From: [REDACTED]
Sent: 28 February 2019 16:44
To: Planning.Responses
Subject: A/9/19/PL Pound Place, Roundstone Lane , Angmering BN16 4AL

Re:- Pound Place, Roundstone, Angmering BN16 4AL

Thank you for your correspondence of 31st January February 2019 requesting an application for the Demolition of existing dwelling & erection of a 62 bedroom care home (C2 Residential Institution) with car park, landscaped gardens & access from Roundstone Lane (resubmission following A/51/18/PL).for which you seek advice from a crime prevention viewpoint.

TREE PROTECTION PLAN

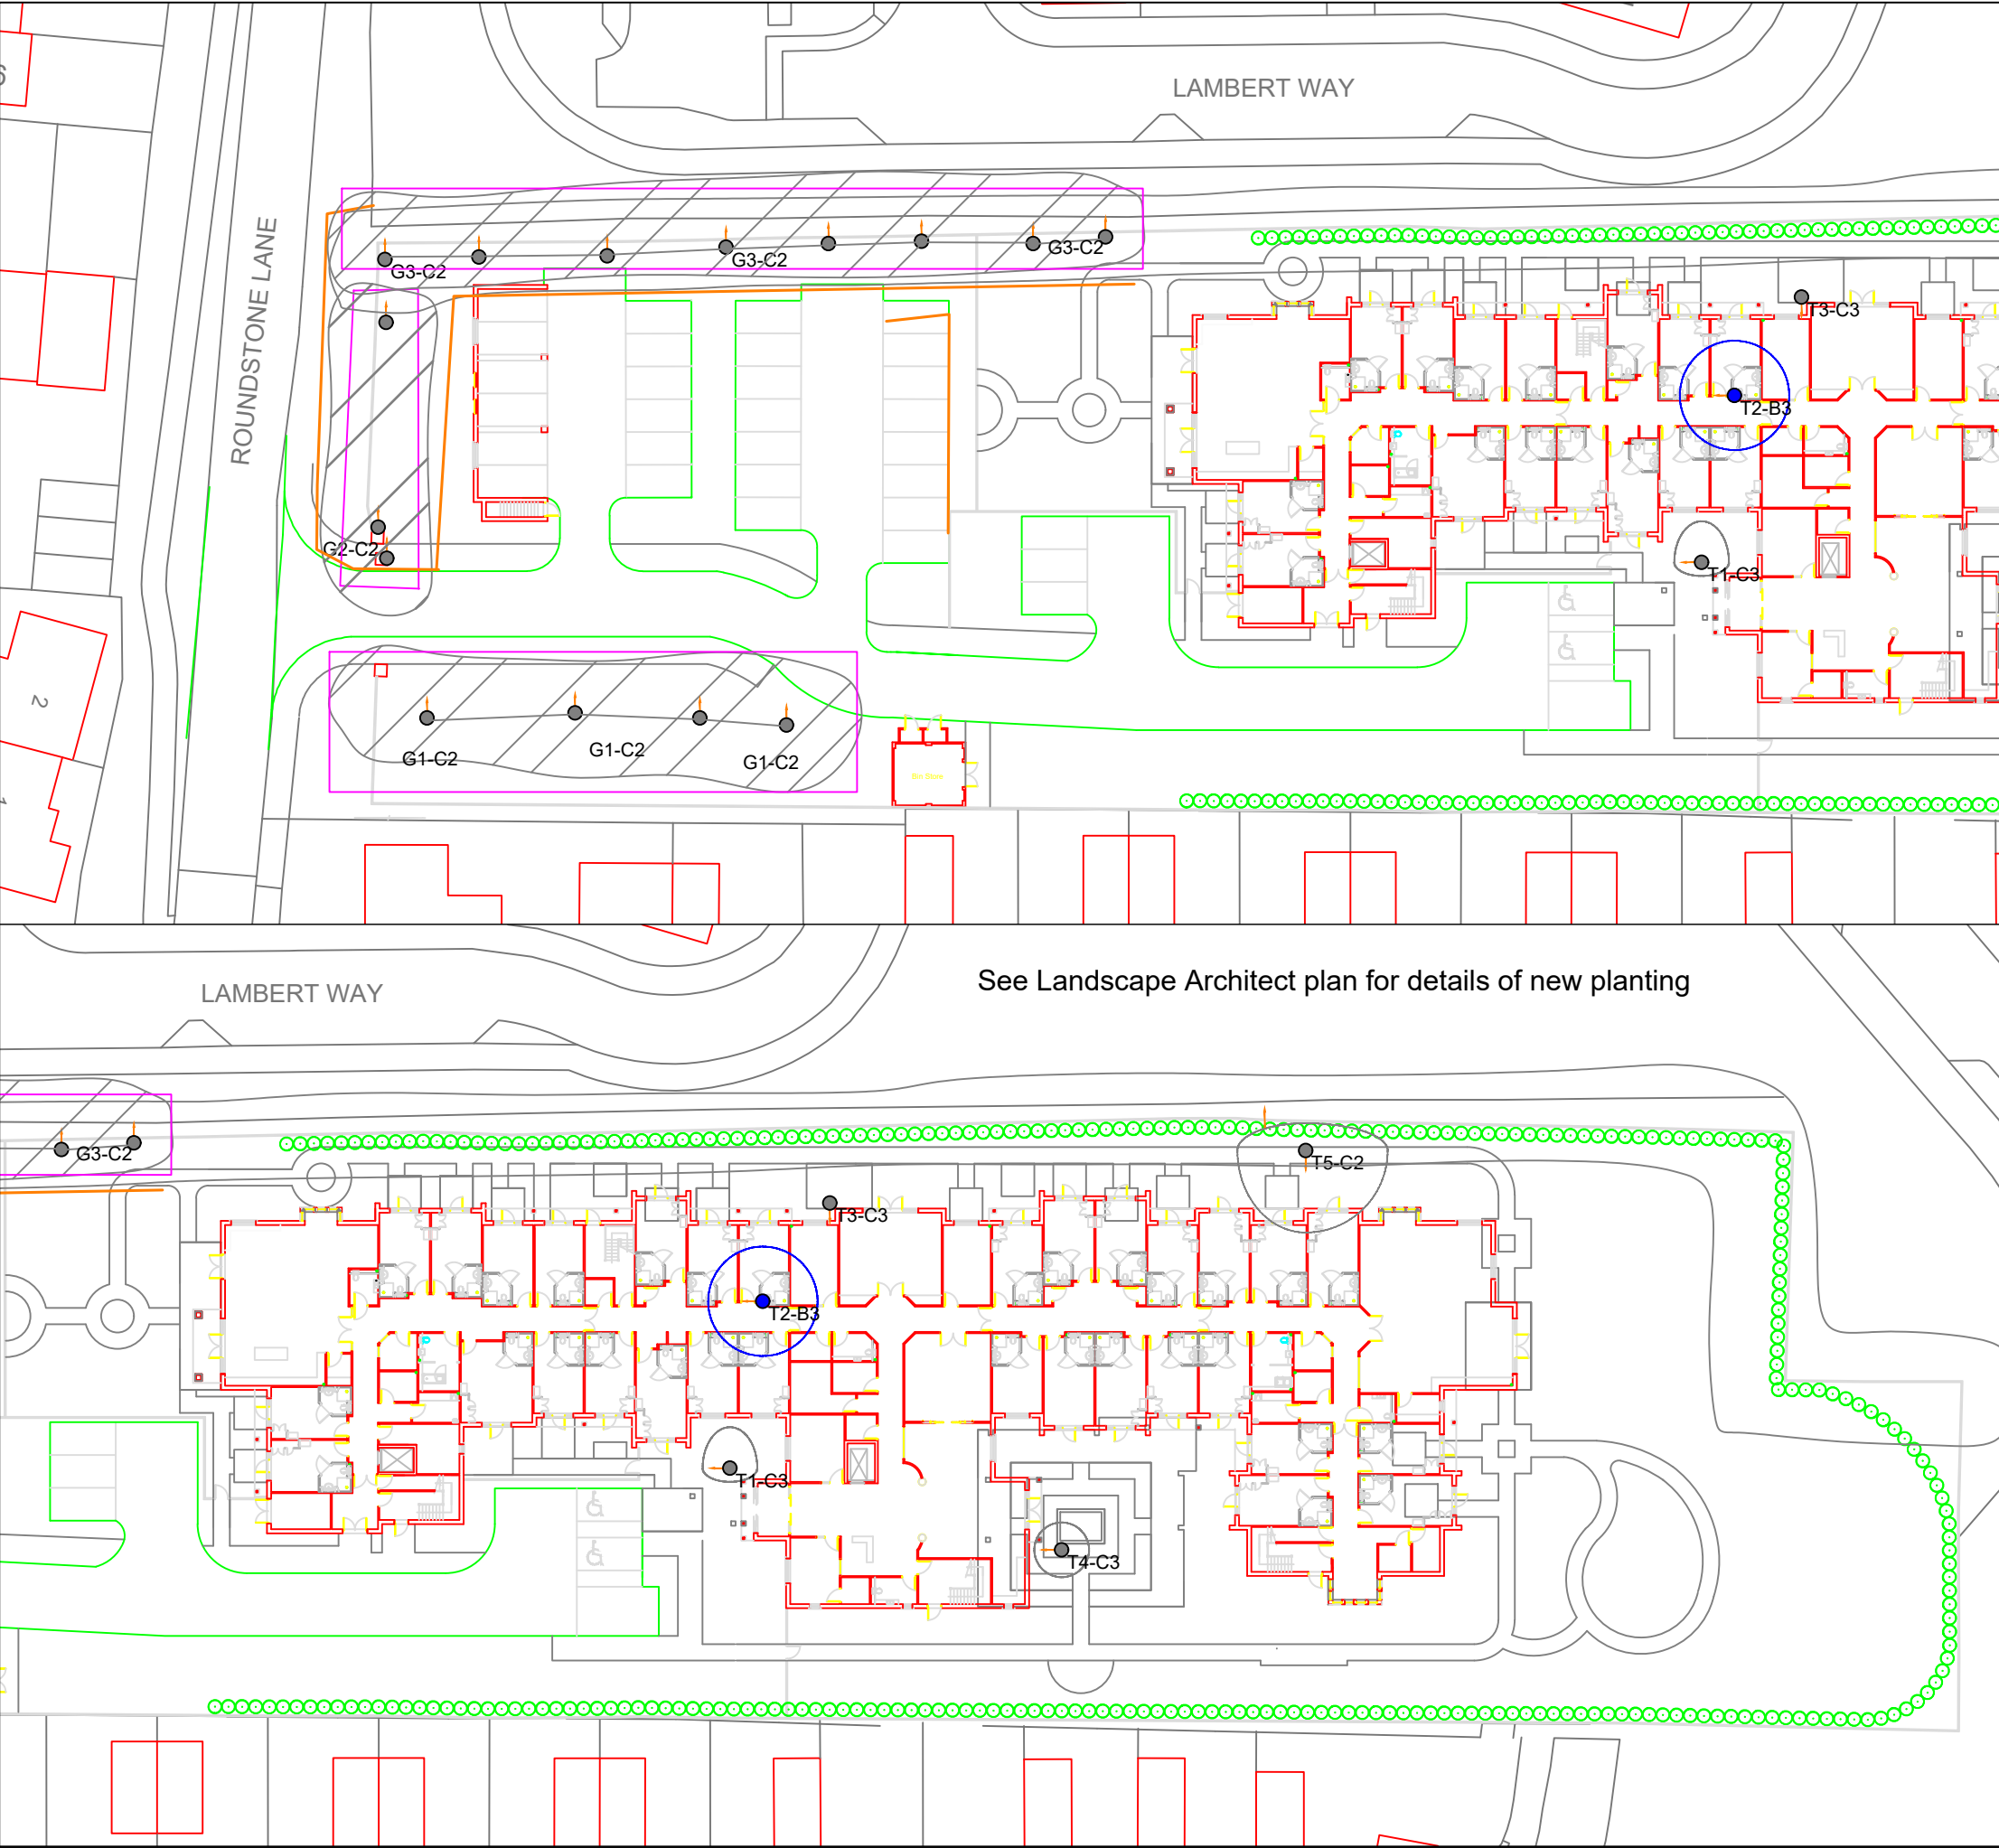
I am pleased to see that there is a secure 1.8m high vertical boarded timber fence and external hedging around the property. There should be no external areas or places where footholds could be gained to gain access to the grounds. Consideration should be given to defensible planting.

Drawing
External Bin Store
Plan & Elevations

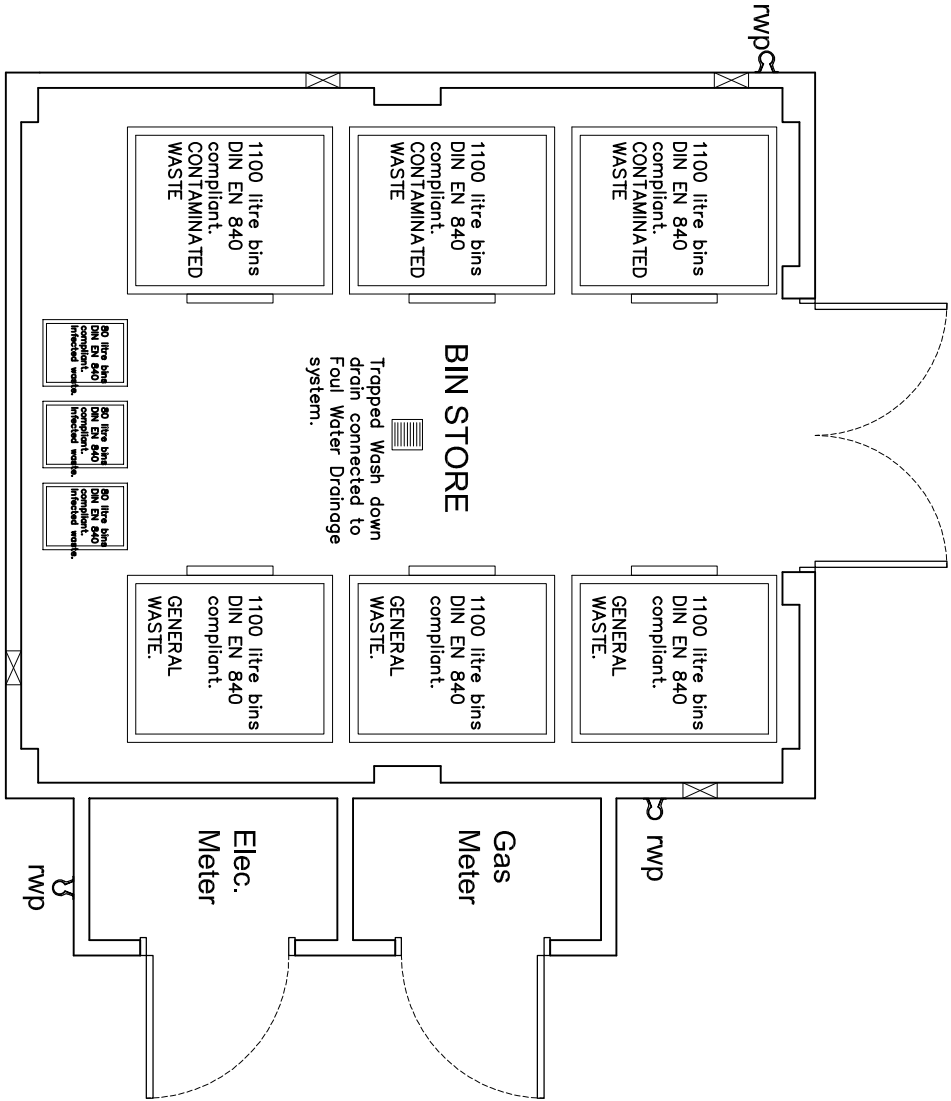
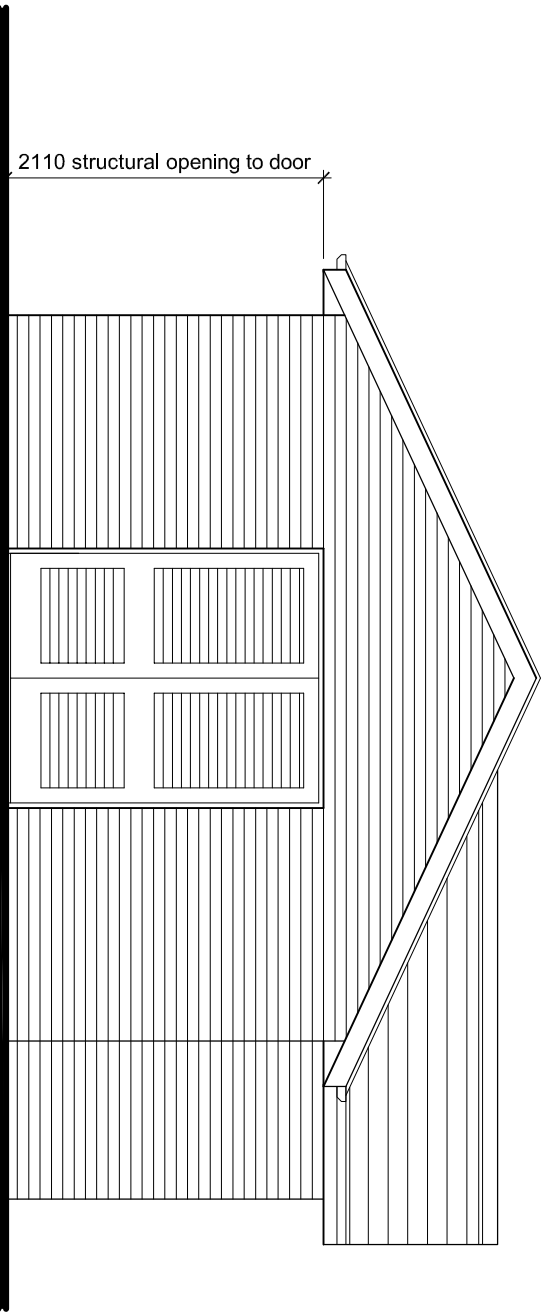
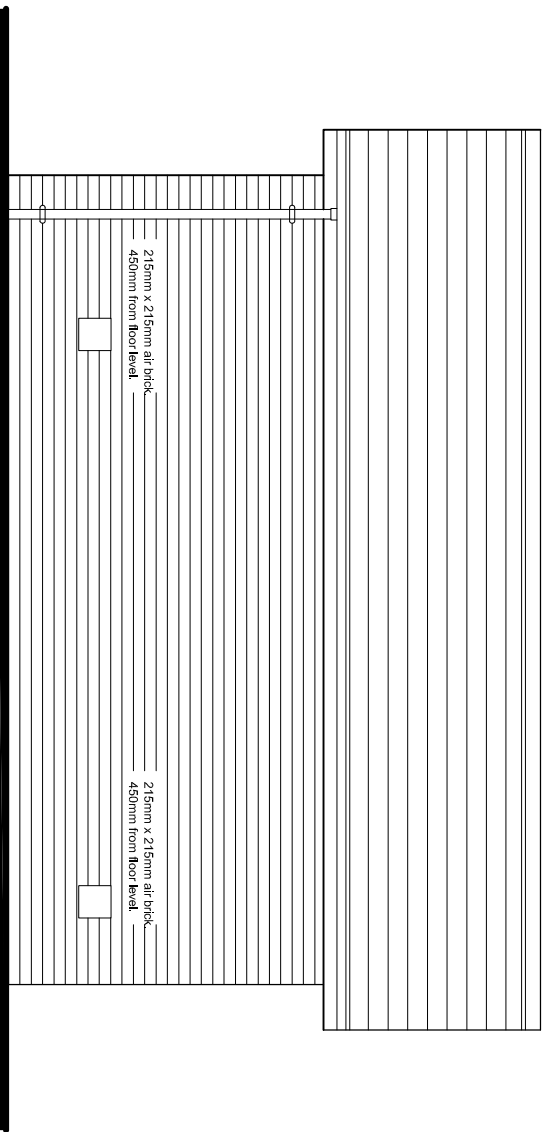
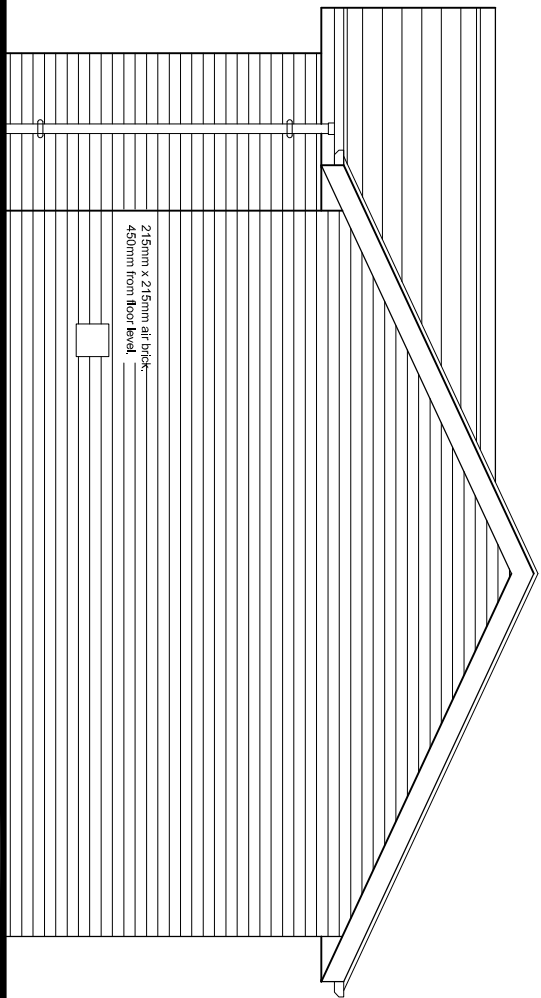
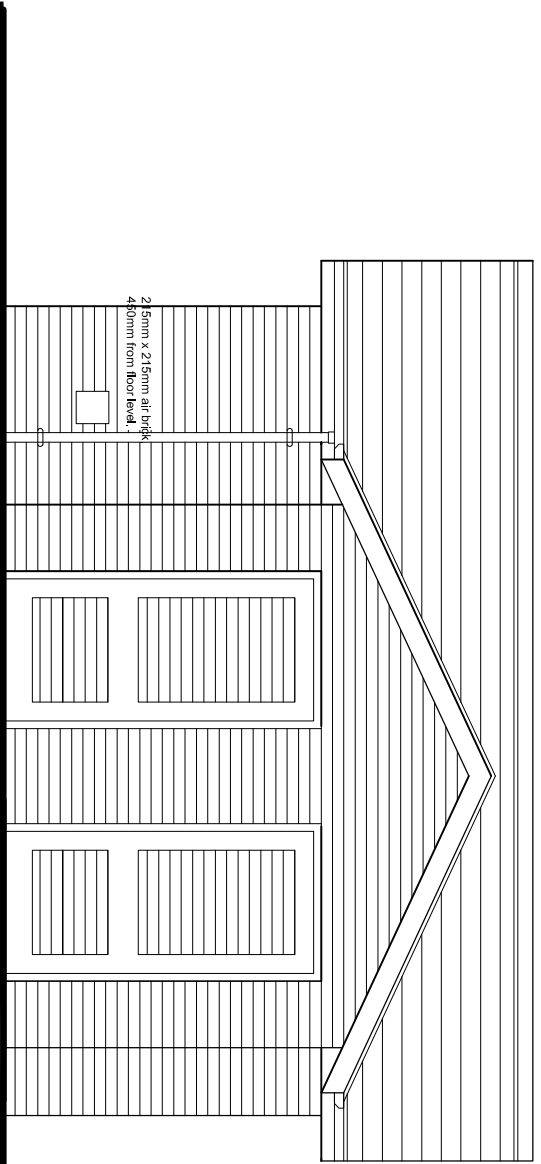
The bin store must also be capable of being locked, and as the store has double doors, a door closer is to be fitted along with spring loaded automatic shoot bolts to the unlocked door to ensure it closes first. The store must be illuminated with a movement activated vandal resistant light.
